# **FENWICK SOLAR FARM**

**Applicant's Summary of Oral Submissions at the Issue Specific  
Hearing (ISH3) on Environmental Matters and Post Hearing  
Notes**

**Document Reference: EN010152 /APP/8.33**

Figure 8-5-2

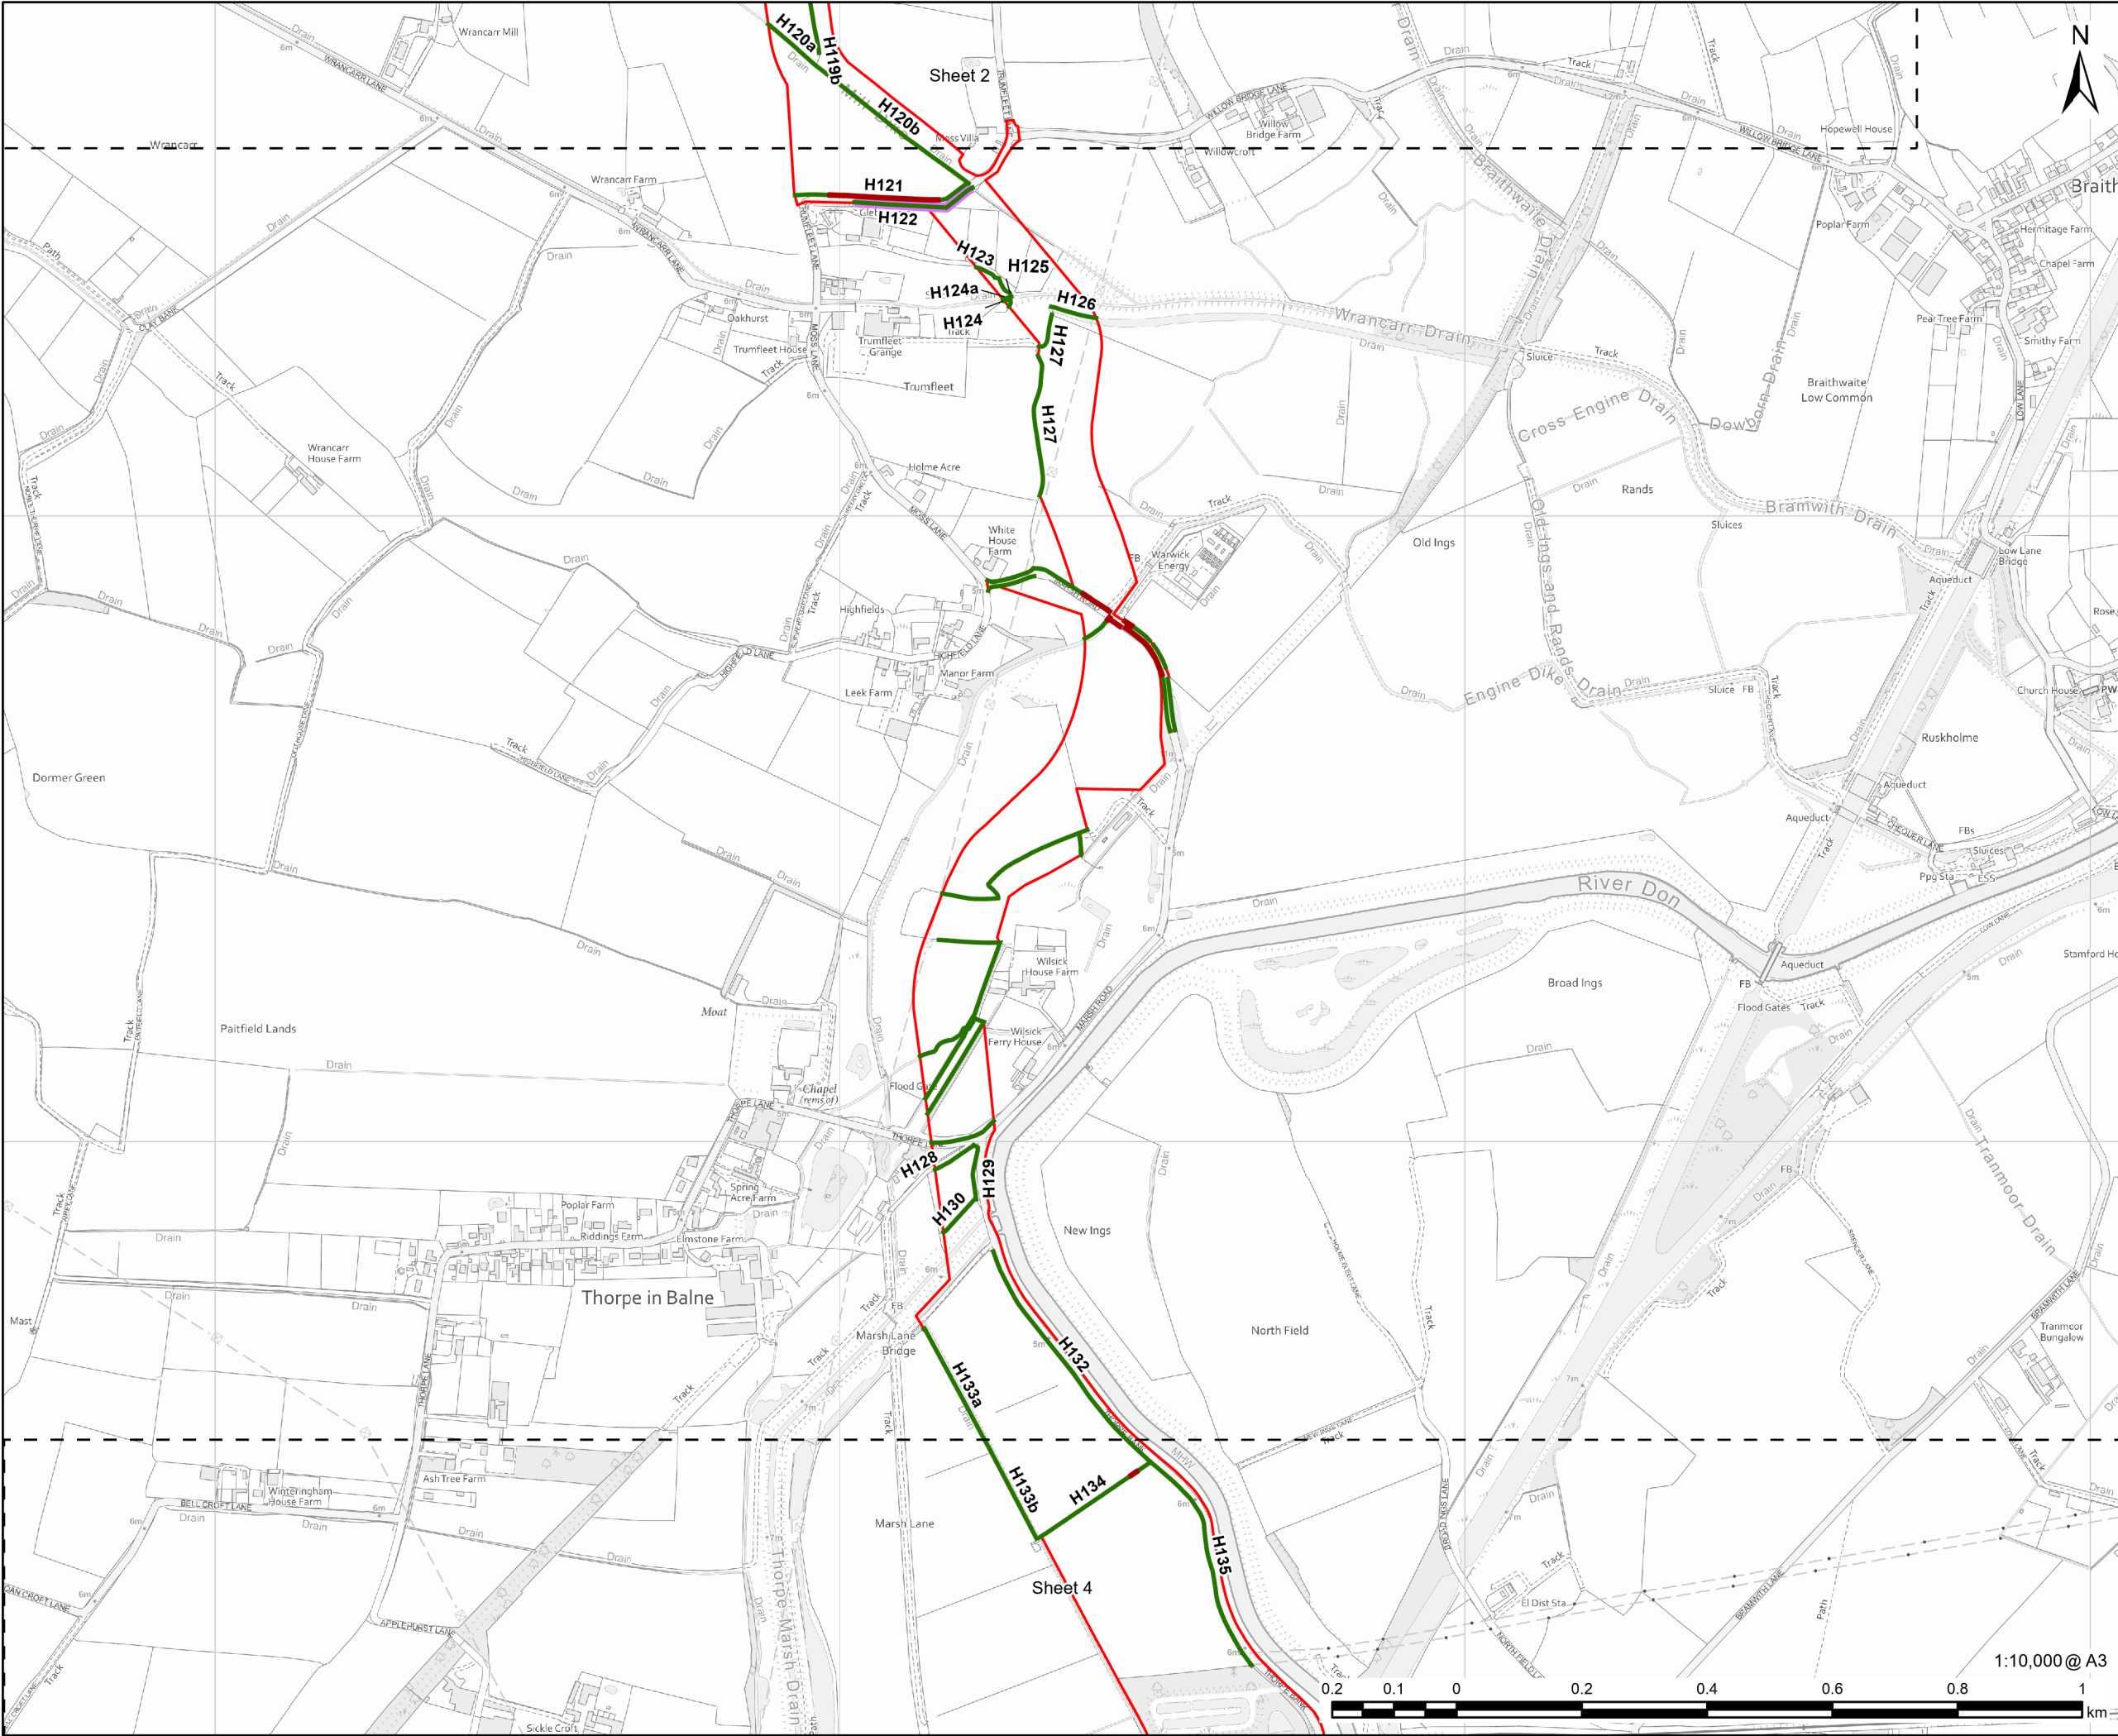
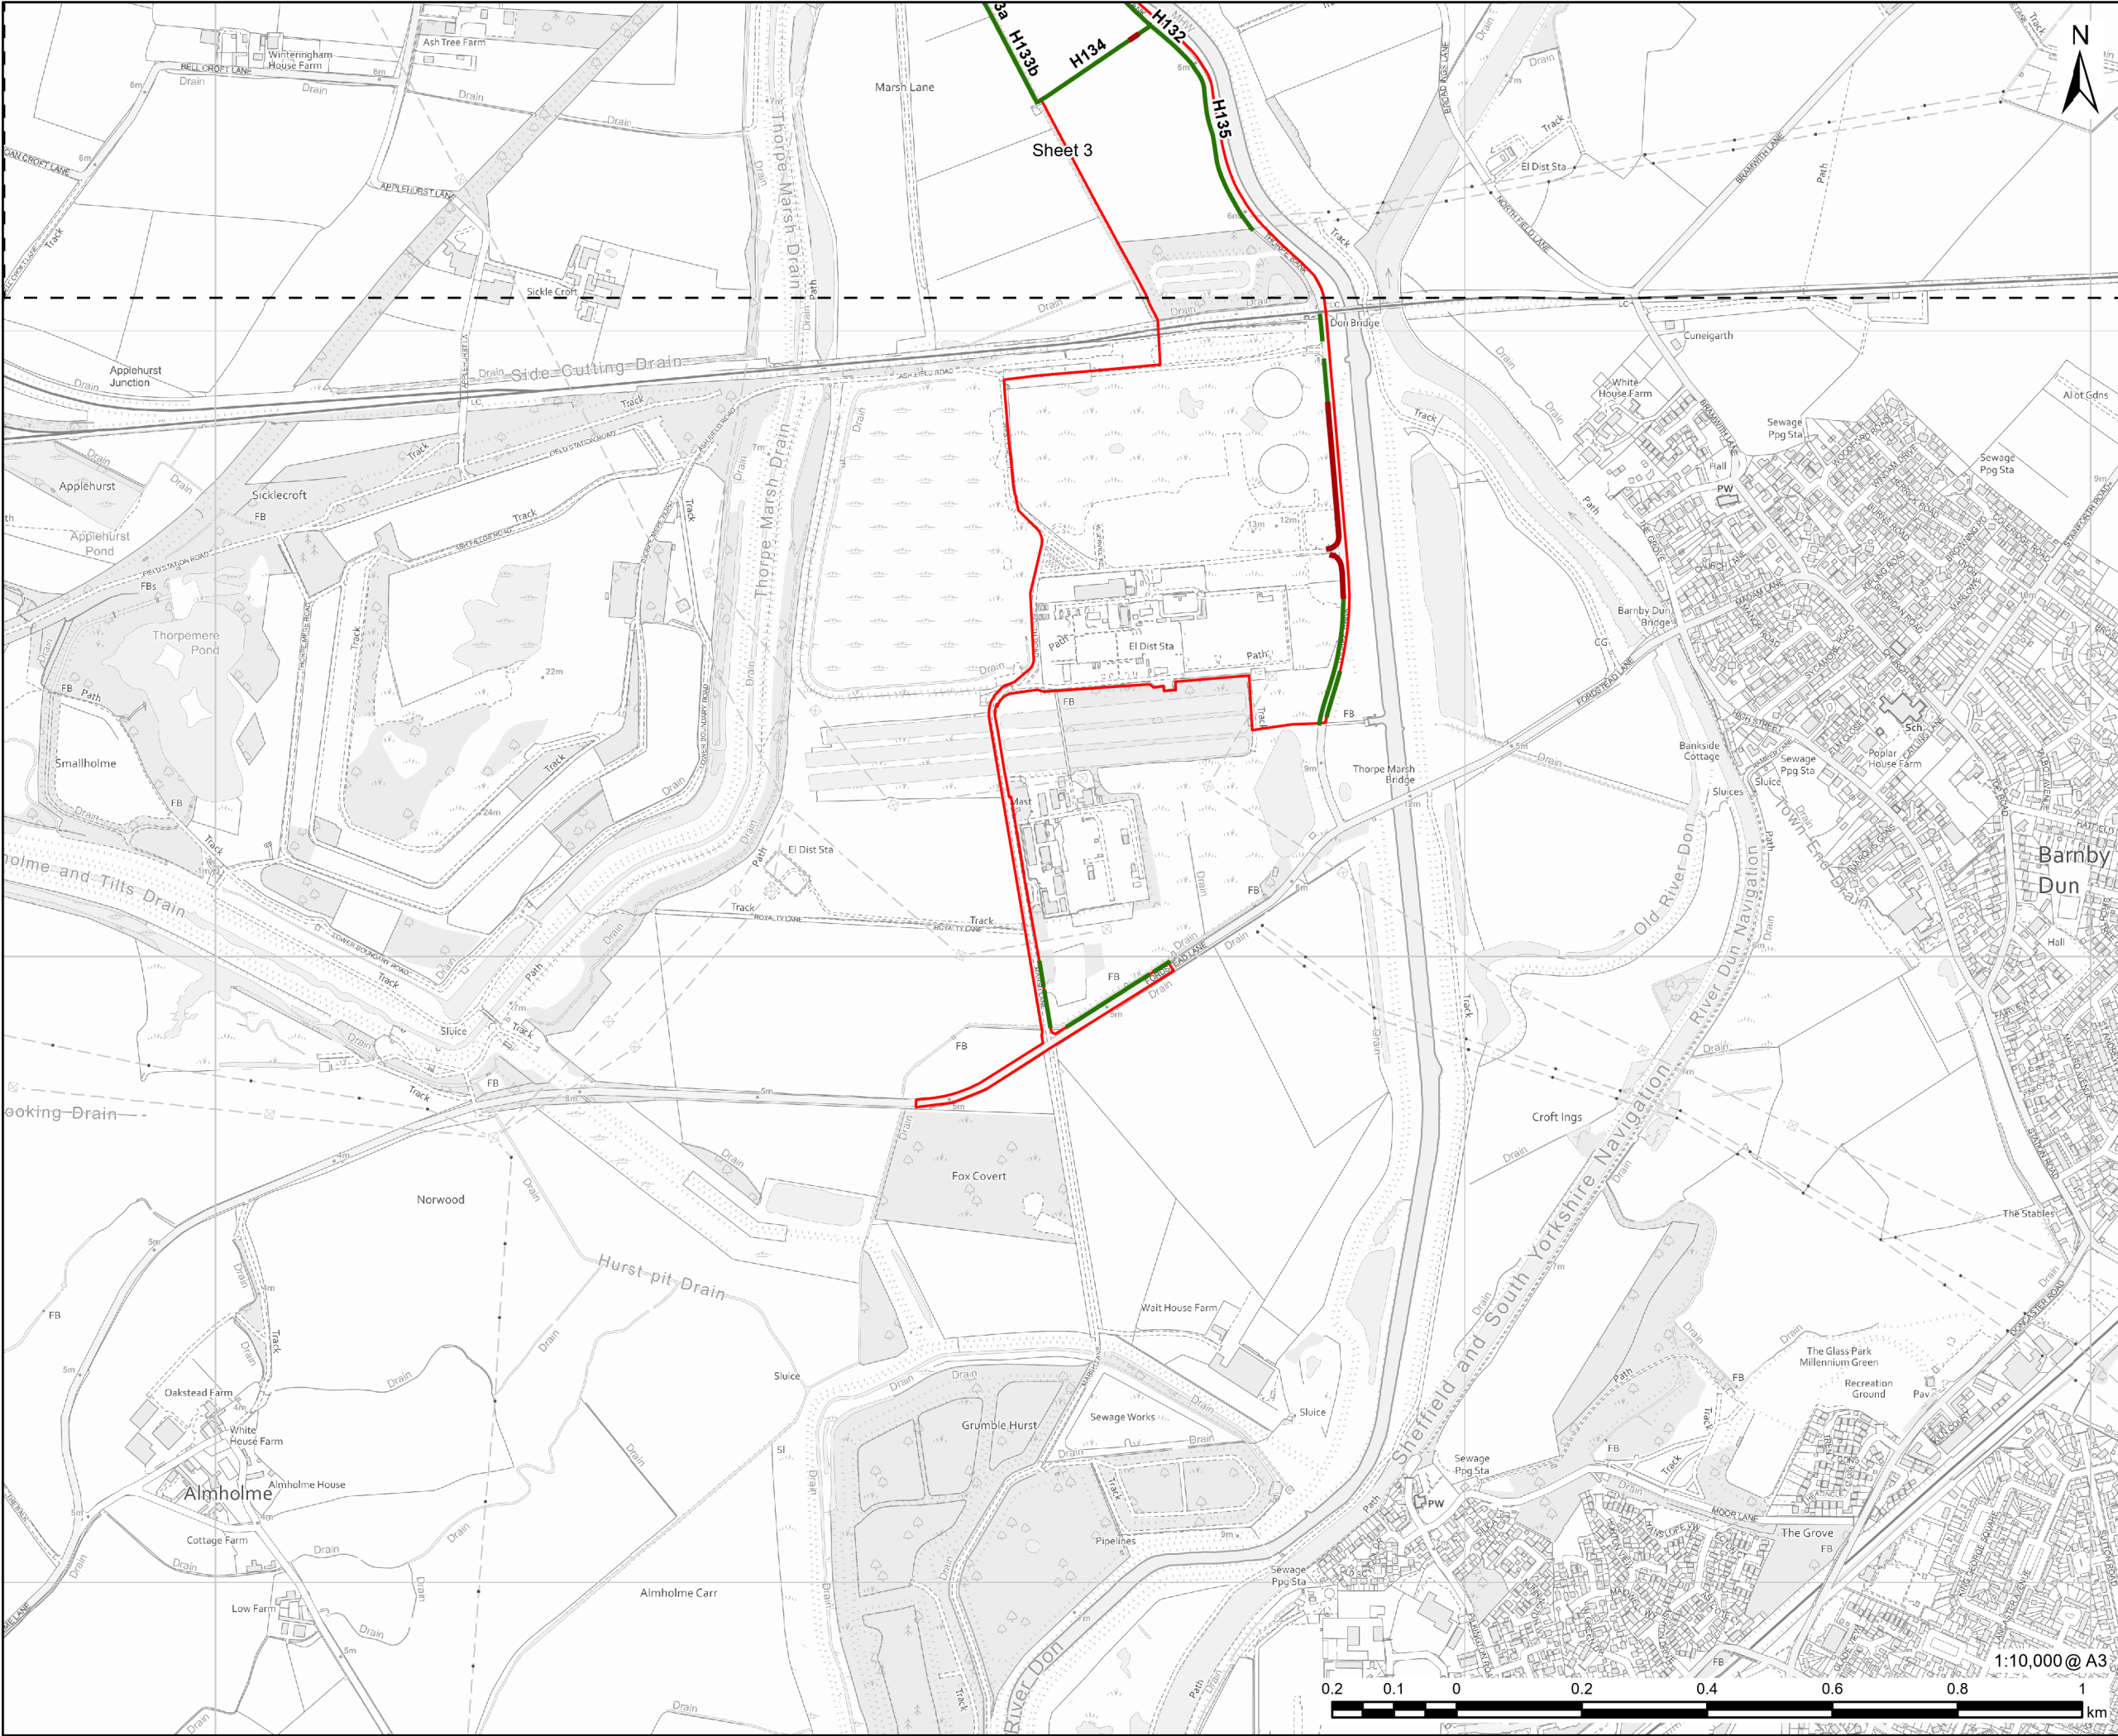
With reference to Annex A of the Hedgerow Report [APP-150], Mr Gates, then provided further details as to the current status of proposed works with particular reference to hedgerows H114a, H115a, H115b, H116a, H121 and H132. The Applicant confirmed that they would submit updated plans at Deadline 3 showing the current predicted areas of hedgerow loss.

The ExA enquired as to why hedges H83 and H96 are not classified as important within the Order Limits.

**Post hearing note:** Figure 8.5.2 [EN010152/APP/6.3] has been updated to reflect the hedgerow removal discussed at ISH3. In particular, the Applicant can confirm that H114a will be subject to a small area of loss at the east end for construction access, which will be re-instated upon completion, but that the loss previously shown in the central section will no longer occur. There will be no loss to H116a.

**Post hearing note:** With reference to Figure 8.5.2 [EN010152/APP/6.3], the Applicant can confirm that neither H83 nor H96 are classified as Important Hedgerows. Figure 8-3 UKHab Plan [APP-094] shows that as H83 and H96 meet the Order Limits, they are no longer classified as hedgerows, but instead as 'w1h - Other woodland; mixed - 29: Plantation' and 'Individual Tree'.
